# ENG-SF22030-R2-GEC-redlines.pdf Markup Summary

STERLING RANCH FILING 4  
 GRADING & EROSION CONTROL PLAN

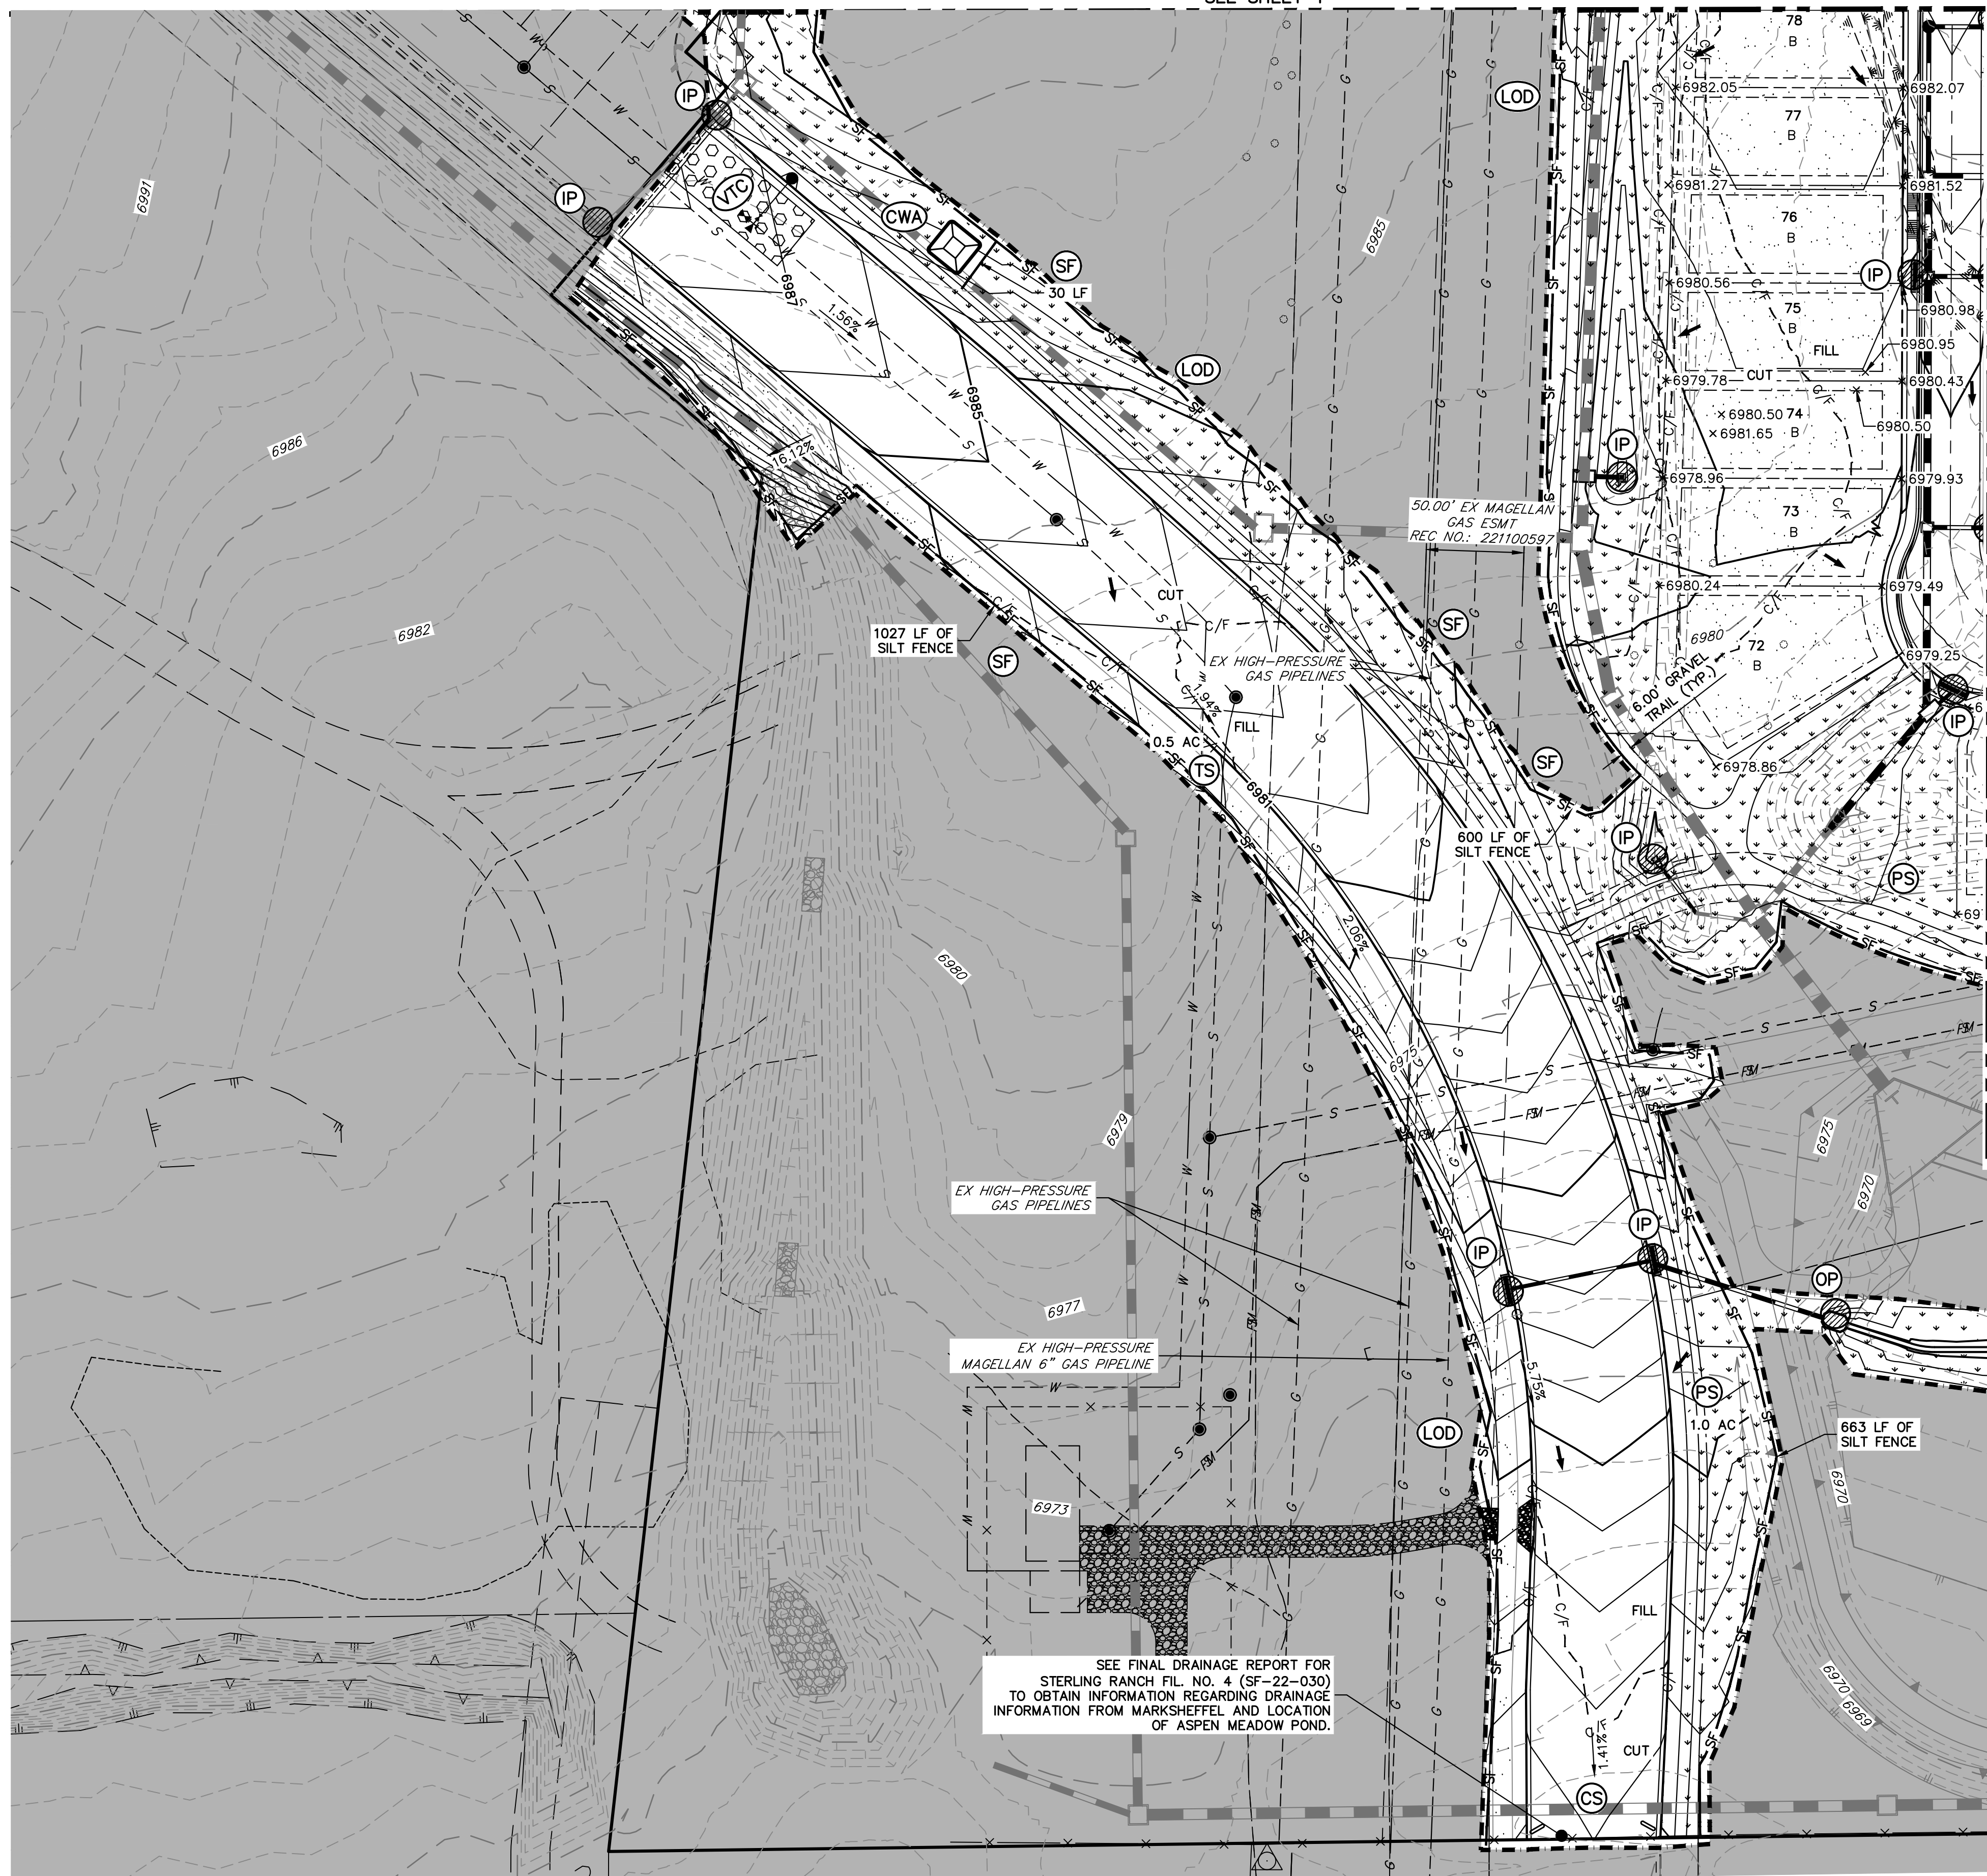
label trail/maint. access roads
